Your ref
Our ref TL /3/2012/1113
Date 8th February 2013

Planning application no: 3/2012/1113
Proposal: Proposed housing development.
Location: Parker Avenue, Clitheroe BB7 1JA.

Trevor Lewis
Traffic and Development Engineer

Working
Site Layouts as Existing and
as Proposed

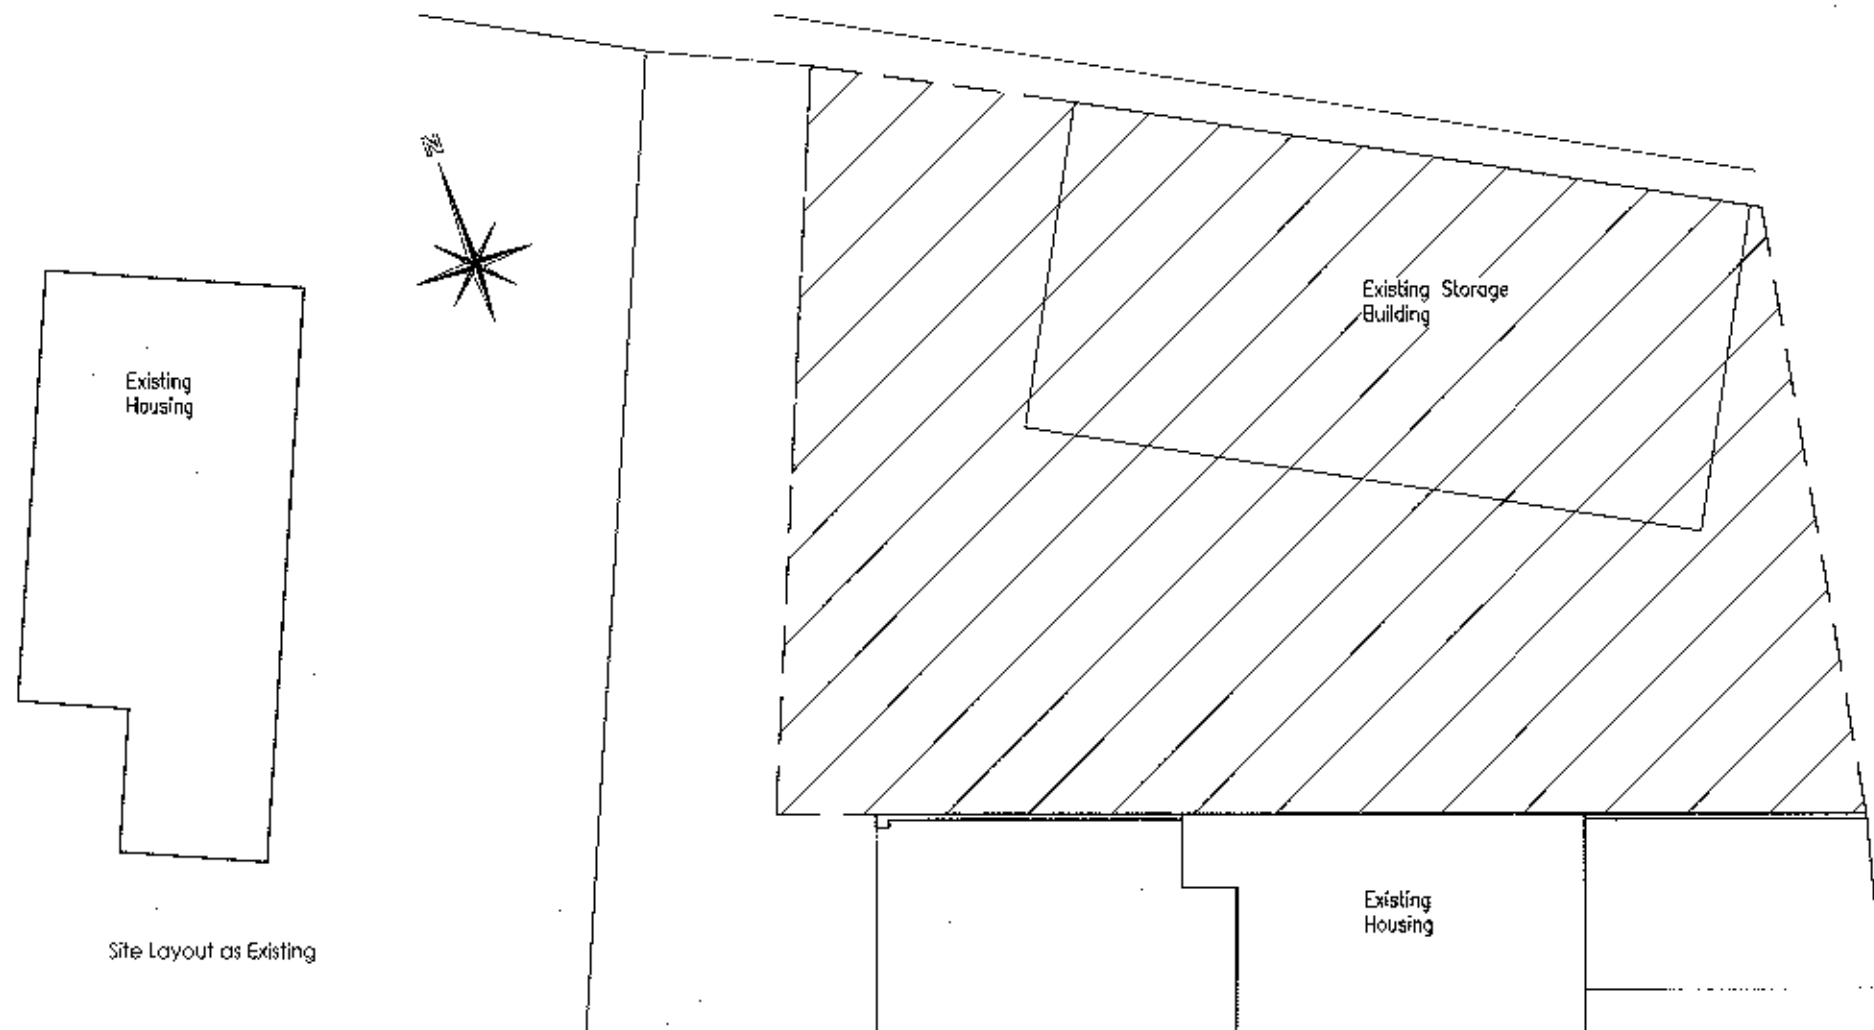
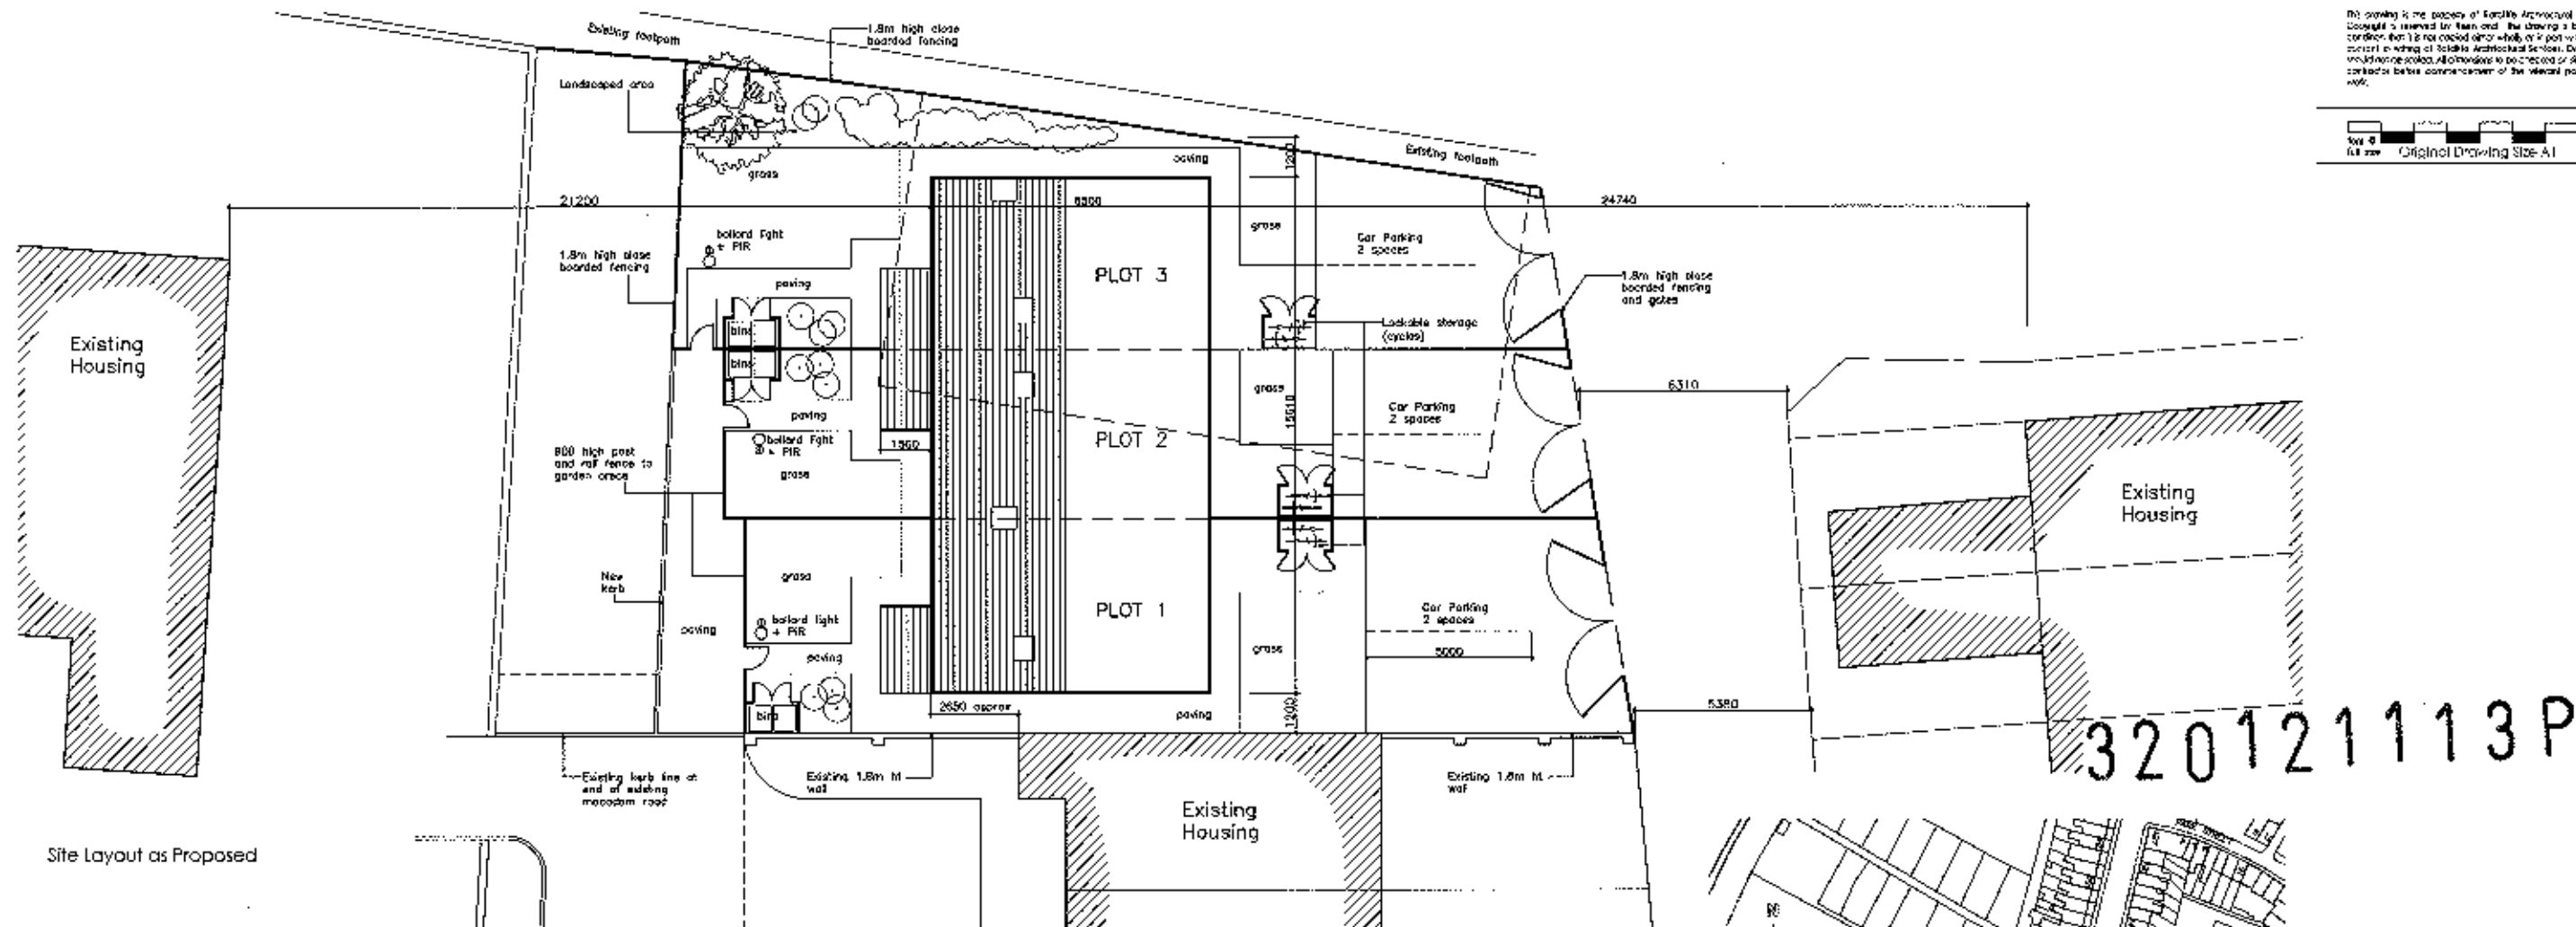
I would prefer and recommend that vehicular access to these dwellings is from the Parker Avenue side of the site. It appears that the ownership of the land to the west of the site has not been determined, but investigations as to the ownership of the land are on-going. I would ask that the developer should delay a decision on this application until the land ownership issue is resolved.

If it is necessary to gain access to the dwellings from back Whalley Road because the land to the west of the site is not owned by the developer, I would have some concerns as to the access onto the adopted highway.

The developer should show that there is a right of access to Whalley Road, as my records indicate that the back street and the link between the gable ends of 180 and 182 Whalley Road are private roads.

Assuming there is a right of access, residents of the new houses will use the more direct link to Whalley Road which is the un-named private street at the gable ends of 180 and 182 Whalley Road. This road is in a poor state of repair and I would ask that this be improved by the developer. This road should be re-surfaced up to the proposed vehicular accesses of the new dwellings.

I would normally ask for the vehicle access gates to be set back 5m from the highway, but as access is onto a private road I would not insist on this. Complying with this requirement

would clearly create some difficulties for the layout of the development and the alternative is to omit the gates from the proposals.

I am not in favour of the high fencing proposed along the footpath and road boundaries of the curtilages of the dwellings, as this does not comply with the guidelines in Manual for Streets. High fences will tend to deter pedestrians from using these routes because the footpaths and roads will not be overlooked, thus creating an environment perceived to be unsafe. High fences will also tend to encourage anti-social behaviour.
